DEPARTMENT OF PUBLIC WORKS

MEMORANDUM

TO: All Staff
FROM: Public Works Plan Review Team
DATE: June 5th, 2023
SUBJECT: LP-23-00002 Tumbling Ridge

TUMBLING RIDGE PRELIMINARY PLAT

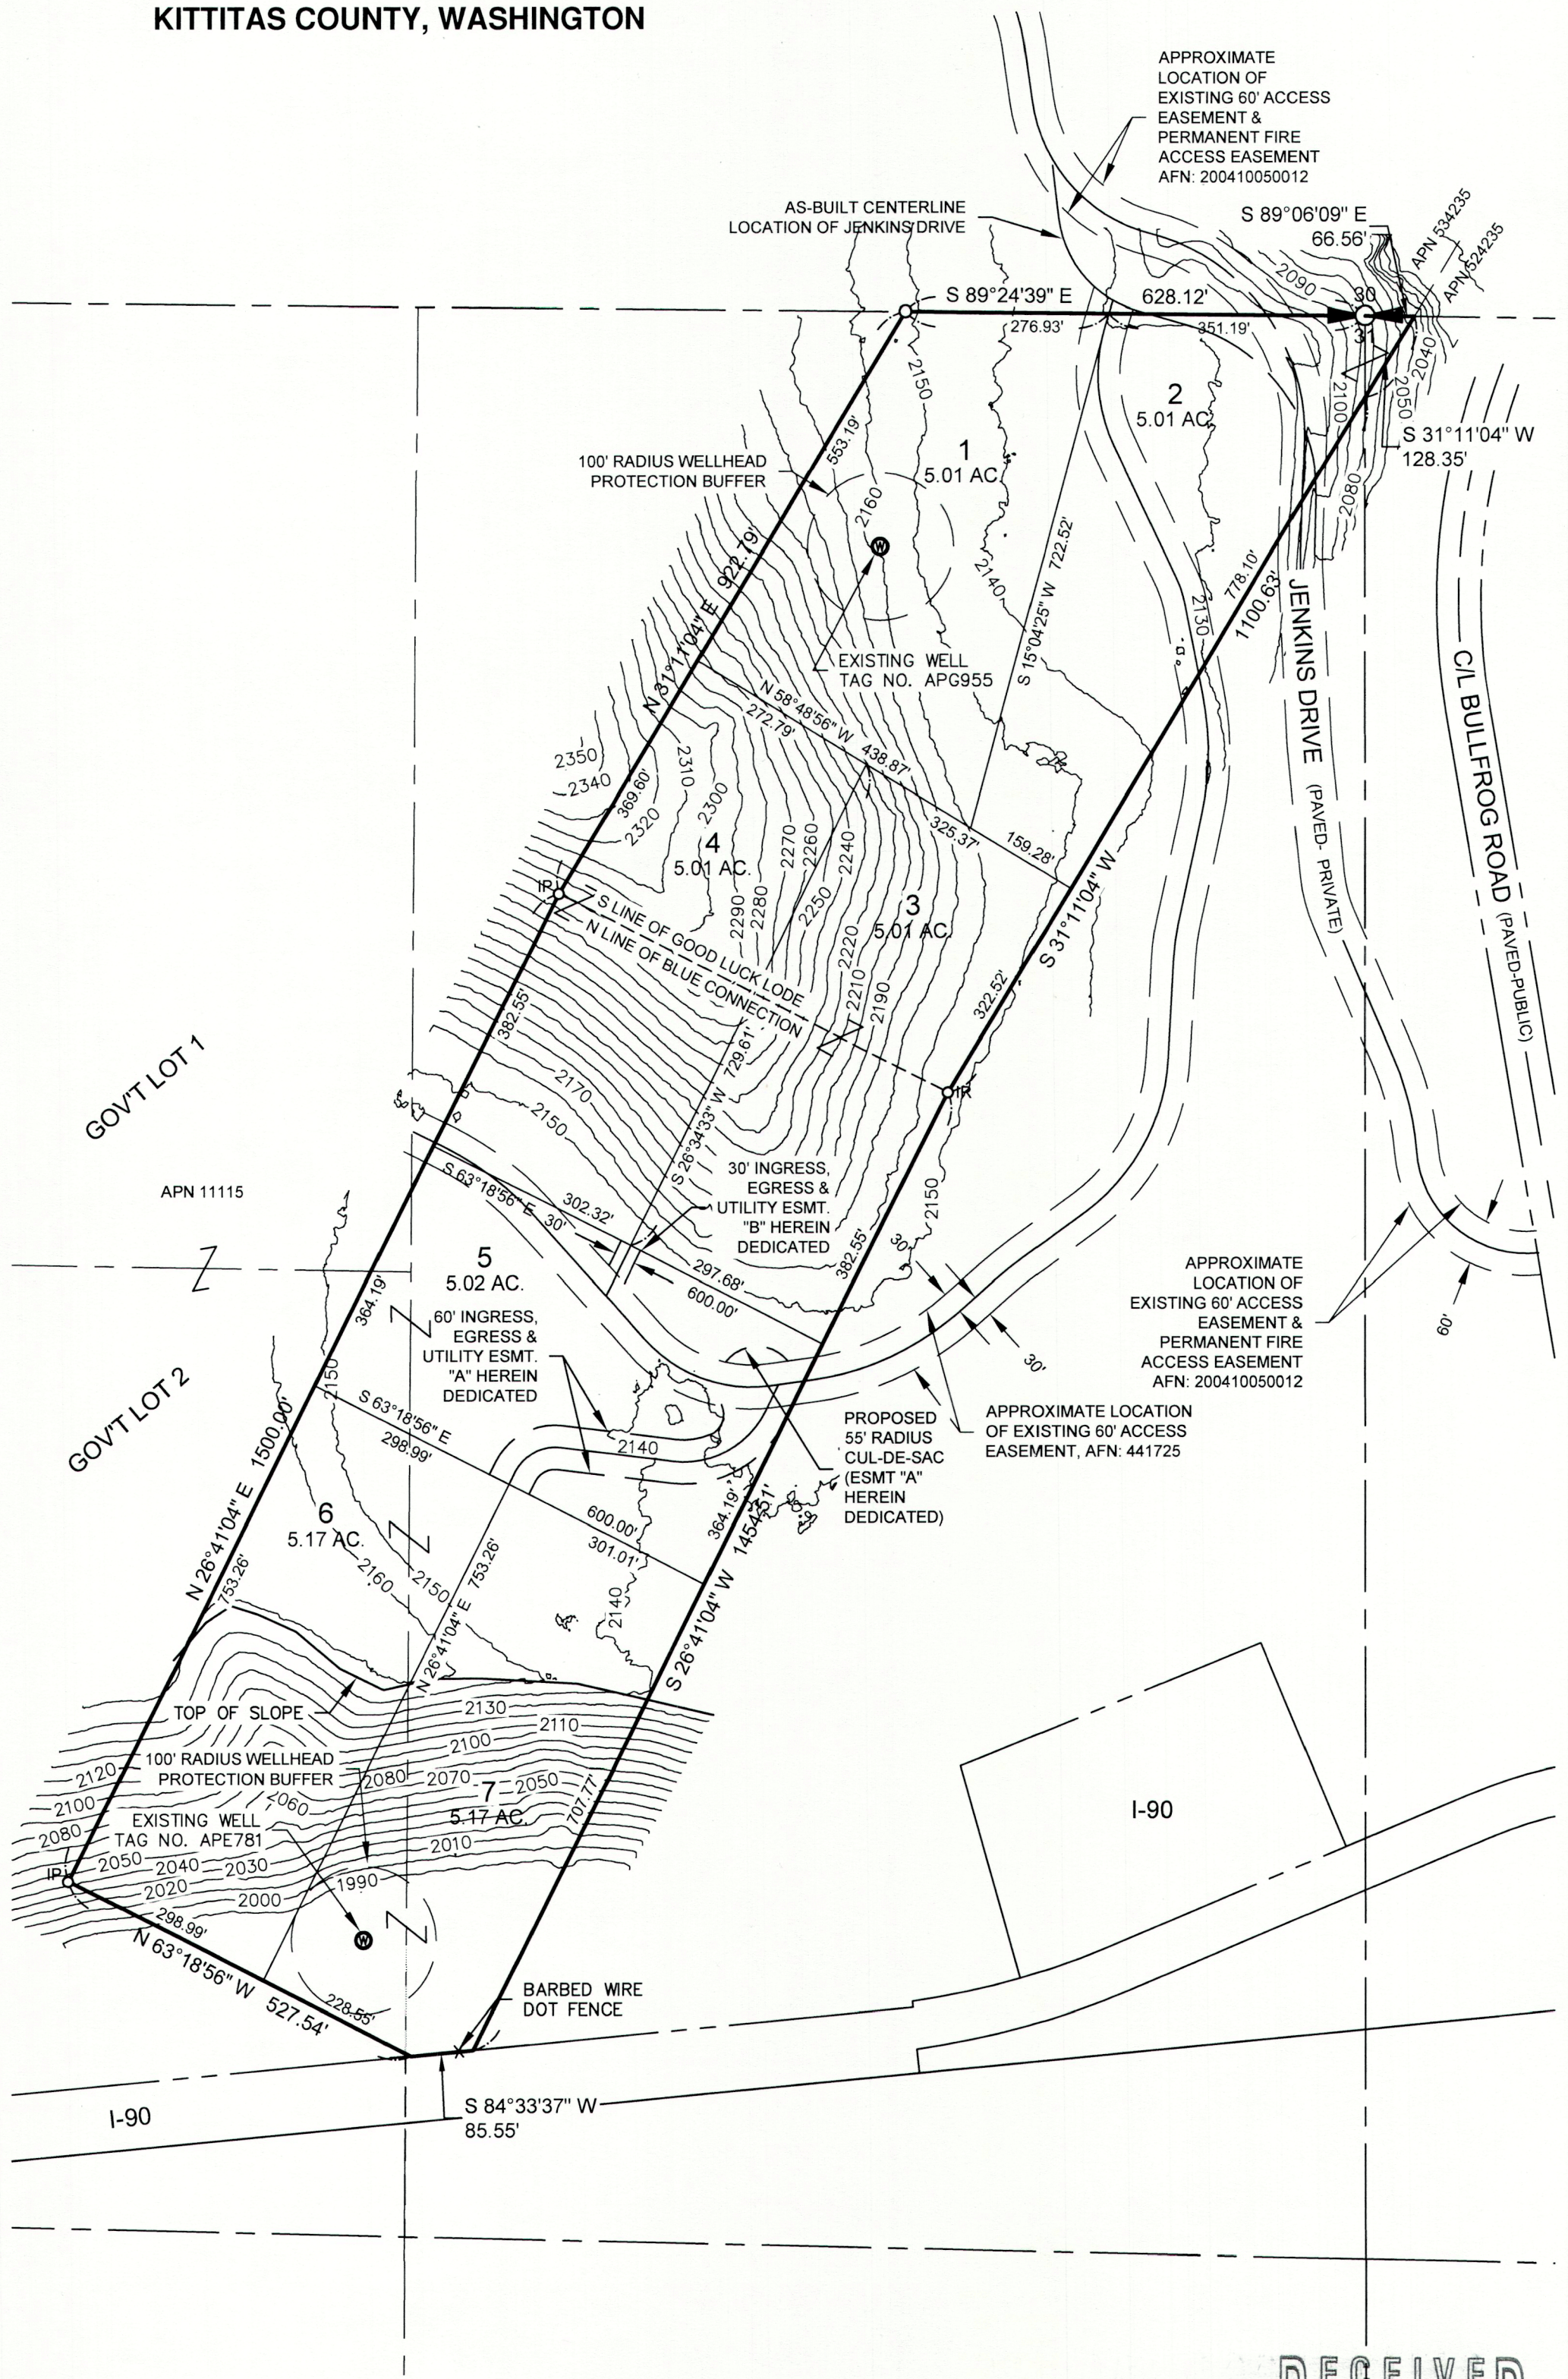
SURVEY	1. Site map does not meet the requirements of WAC 332-130-145. (JT)
TRANSPORTATION CONCURRENCY	1. Concurrency evaluation is required per KCC 12.10.040
FLOOD	Parcel #s 952139 and 952140 are not located in the special flood hazard area (100-year floodplain).
WATER MITIGATION/ METERING	<p>For the proposed plat, the applicant must provide legal water availability for all new uses on the proposed lots of this project, which can be provided through mitigation certificates. Plats are not eligible for the Kittitas County Water Bank, water mitigation must be purchased from a private water bank.</p> <p>Prior to final plat approval and recording, the following conditions shall be met:</p> <p>In accordance with KCC Chapter 13.35.027, the applicant shall provide one of the following documents before final plat approval:</p> <ol style="list-style-type: none"> 1. A letter from a water purveyor stating that the purveyor has adequate water rights and will provide the necessary water for the new use; 2. An adequate water right for the proposed new use; or 3. A certificate of water budget neutrality from the Department of Ecology or other adequate interest in water rights from a water bank. <p>All applicants for land divisions shall also submit information on "proximate parcels" held in "common ownership" as those terms are defined in WAC 173-539A-030 and otherwise demonstrate how the proposed new use will not violate RCW 90.44.050 as currently existing or hereafter amended.</p> <p>Failure to obtain mitigation before commencement of an activity requiring mitigation shall be a code violation subject to enforcement under Title 18 KCC.</p> <p>Final Plat Notes</p> <p>The following notes shall be placed on the face of the plat:</p> <p>C-1 "Metering is required for all new uses of domestic water for residential well connections and usage must be recorded in a manner consistent with Kittitas County Code Chapter 13.35.027 and Ecology regulations."</p> <p>C-2 "The approval of this division of land provides no guarantee that use of water under the ground water exemption (RCW 90.44.050) for this plat or any portion thereof will not be subject to curtailment by the Department of Ecology or a court of law."</p>
